From: Ewan Stoddart [REDACTED]
Sent: 30 October 2018 10:56
To: Planning.Responses; Planning
Subject: RE: Further Information Required on Your Ref: PP-07380117 Our Ref: LY/18/18/HH

Further to your email letter of 29th October please find attached the following amended drawings in order to validate our application.

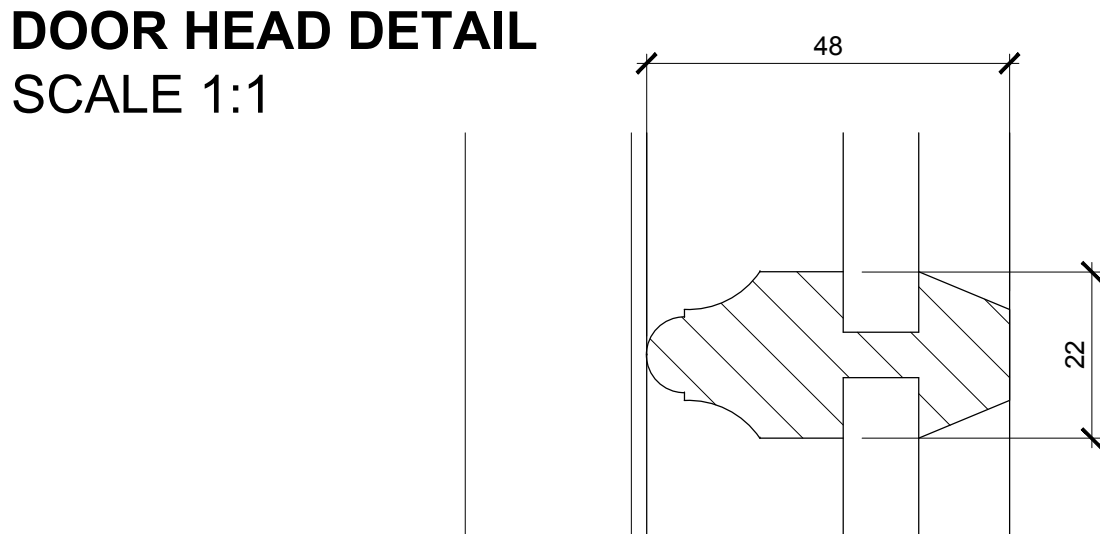
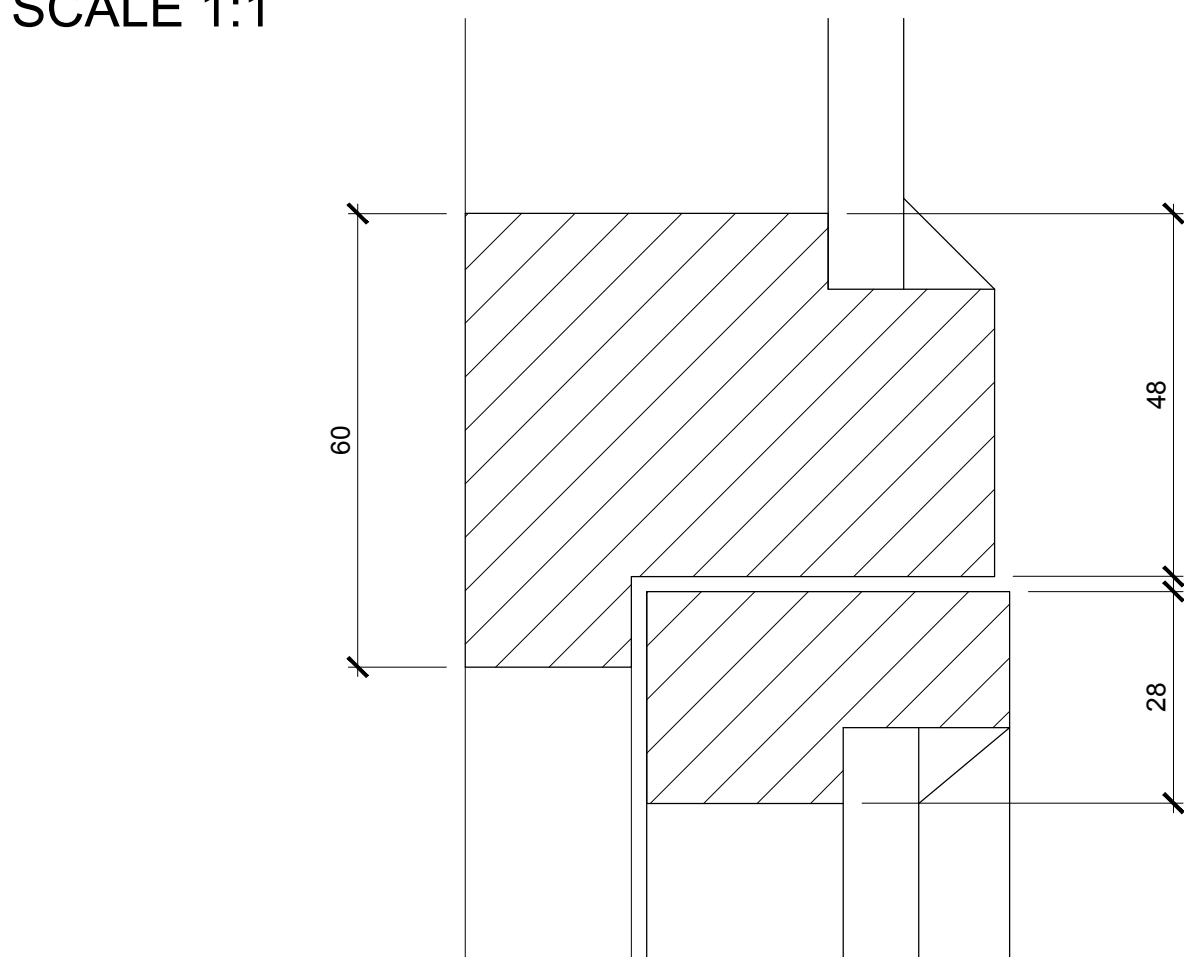
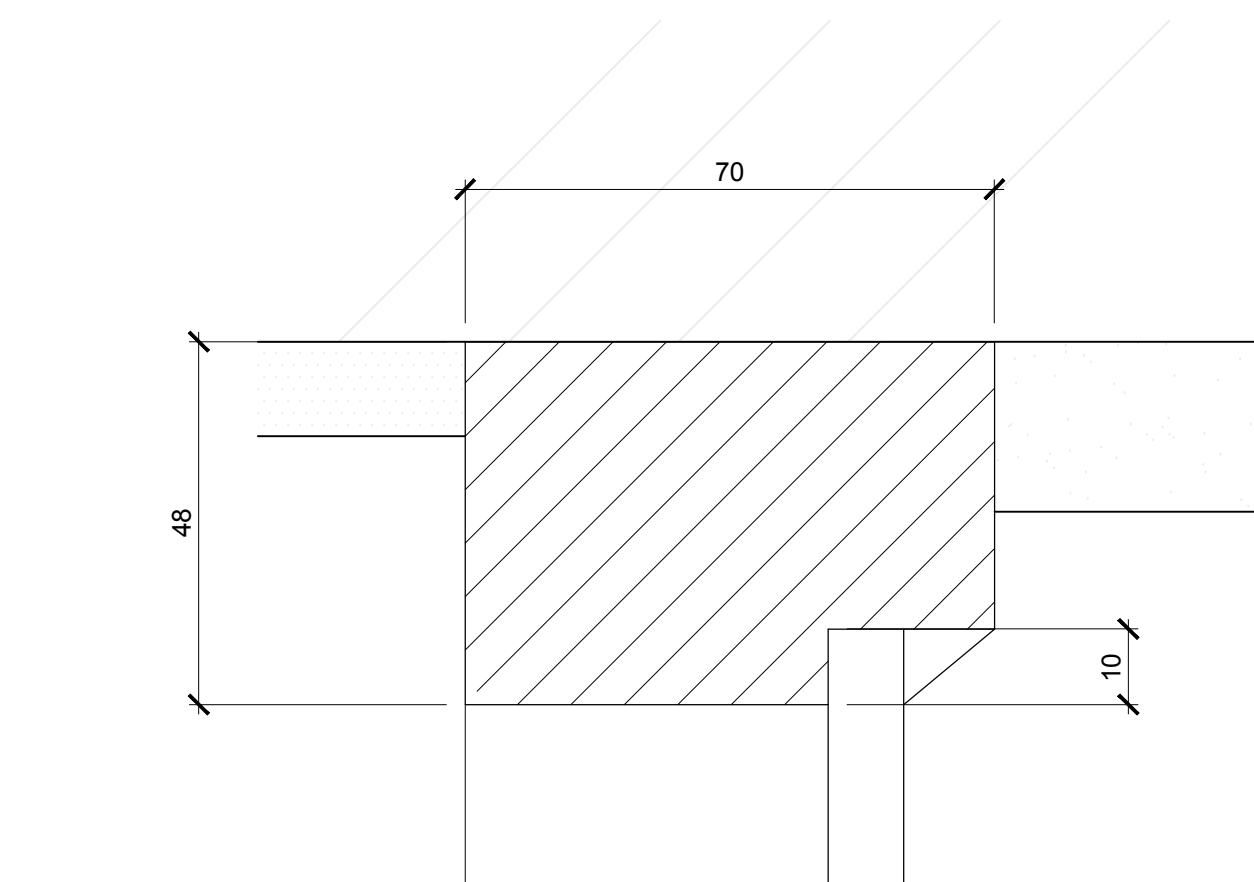
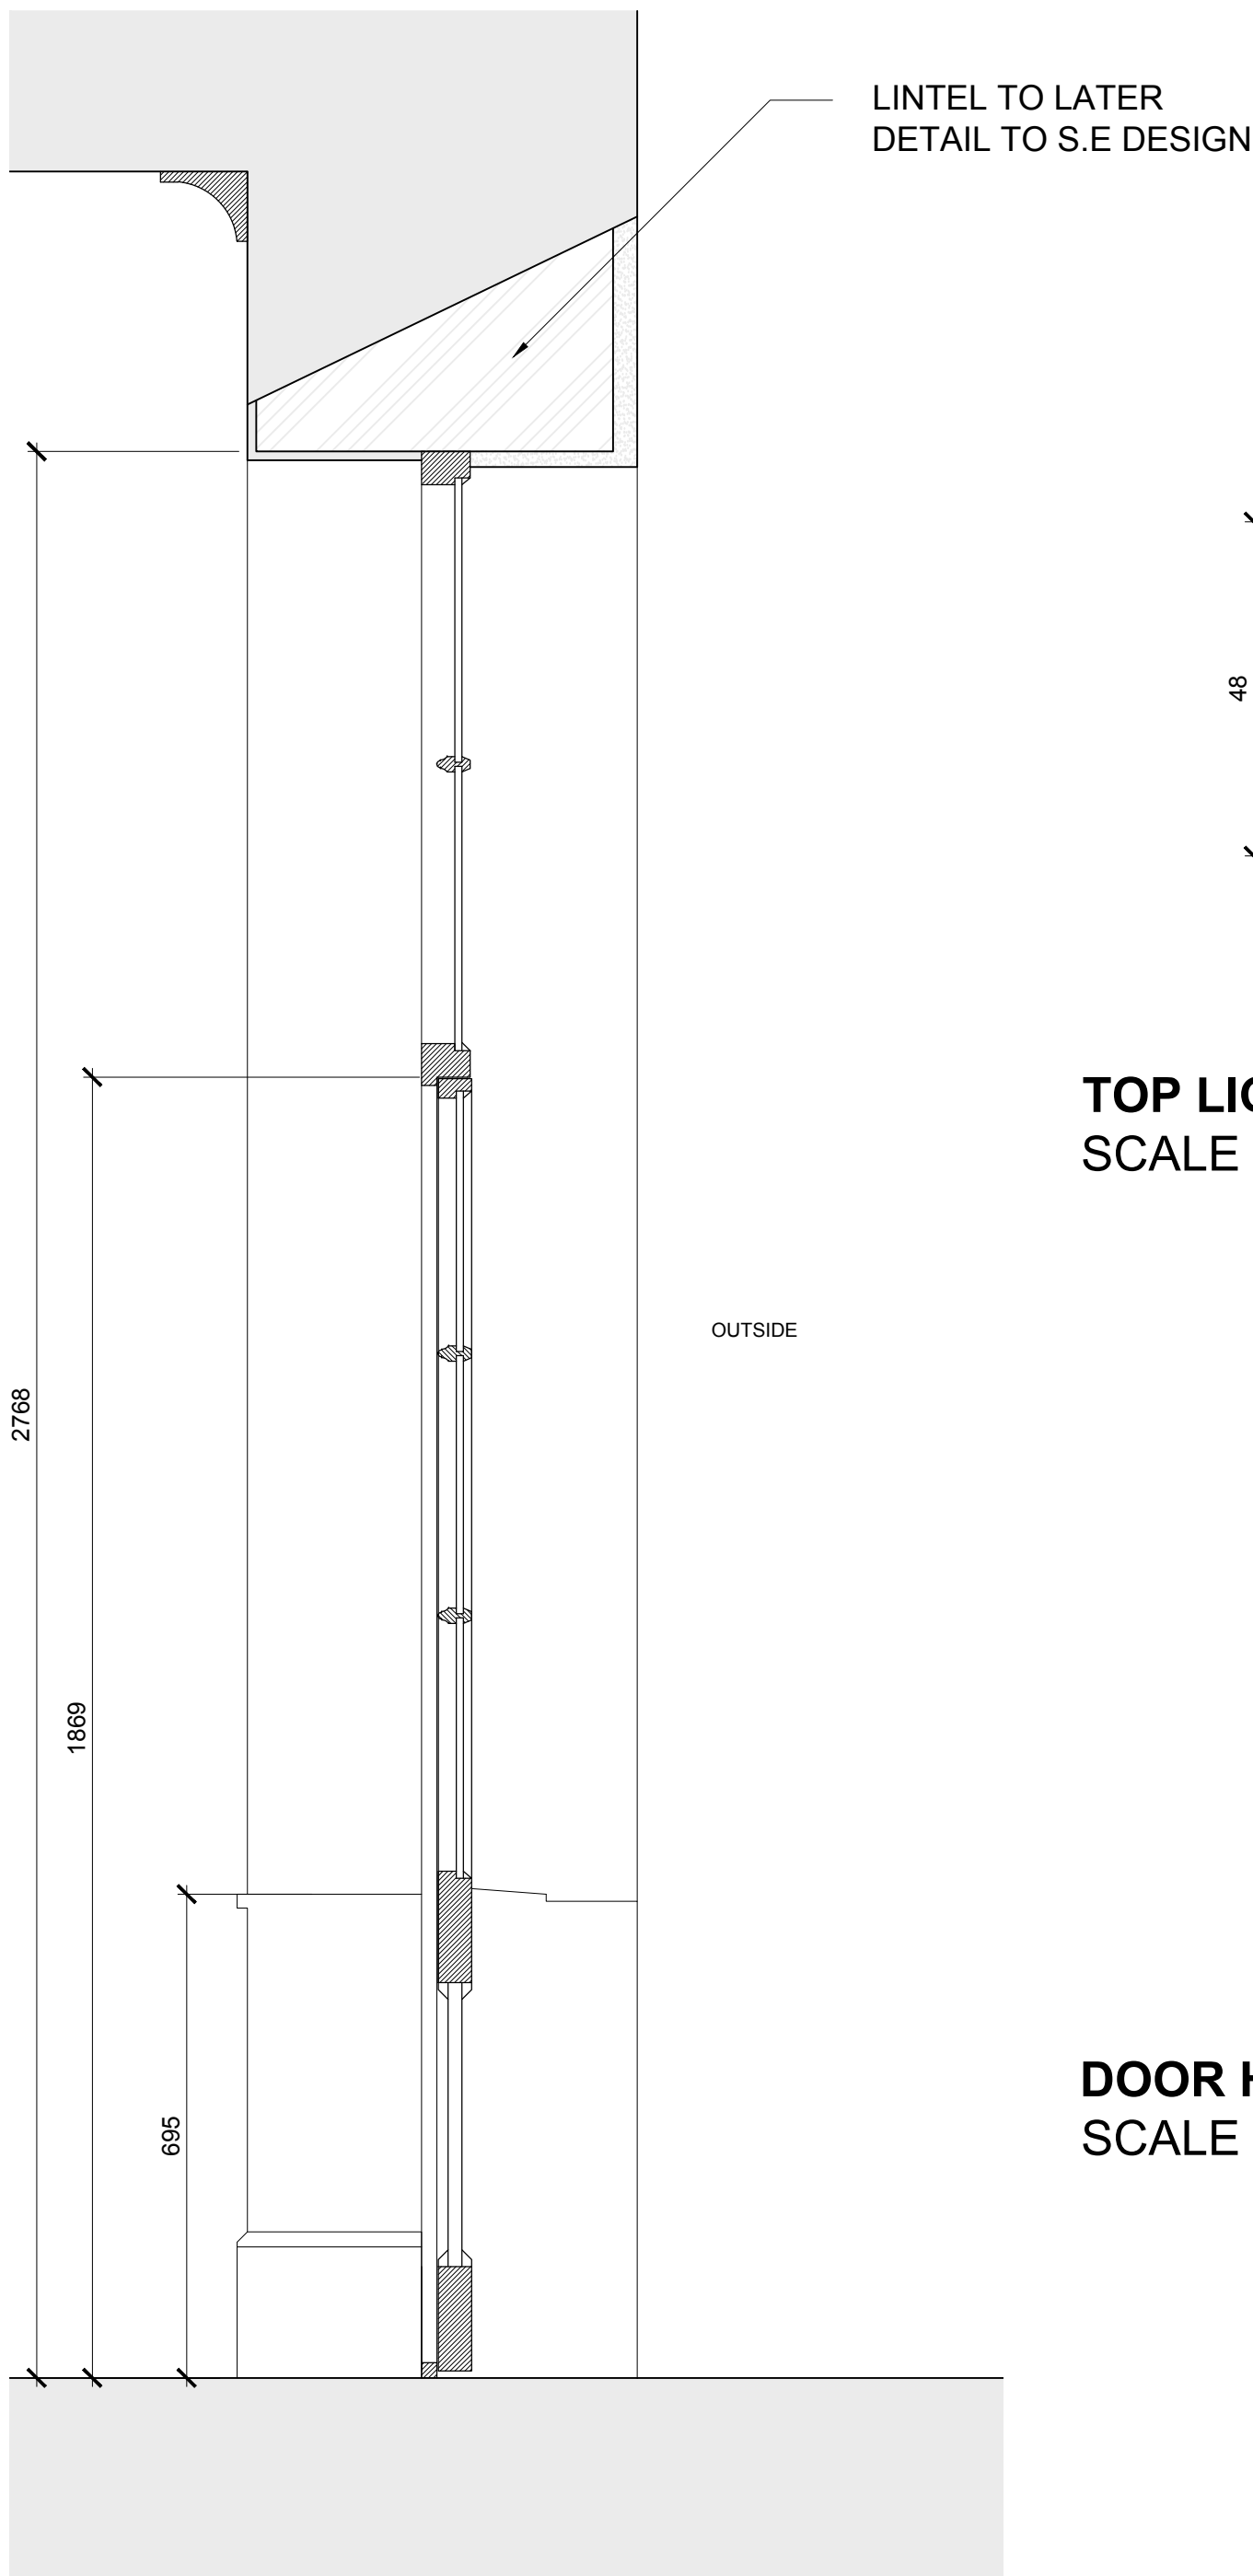
Elevations: The elevations of the door do not measure to the stated scale of 1:100. Please review and amend accordingly.

Savills Response – Please find attached a set of updated existing and proposed door elevations that now correctly states 1:10 Scale (not 1:100 which was in error).
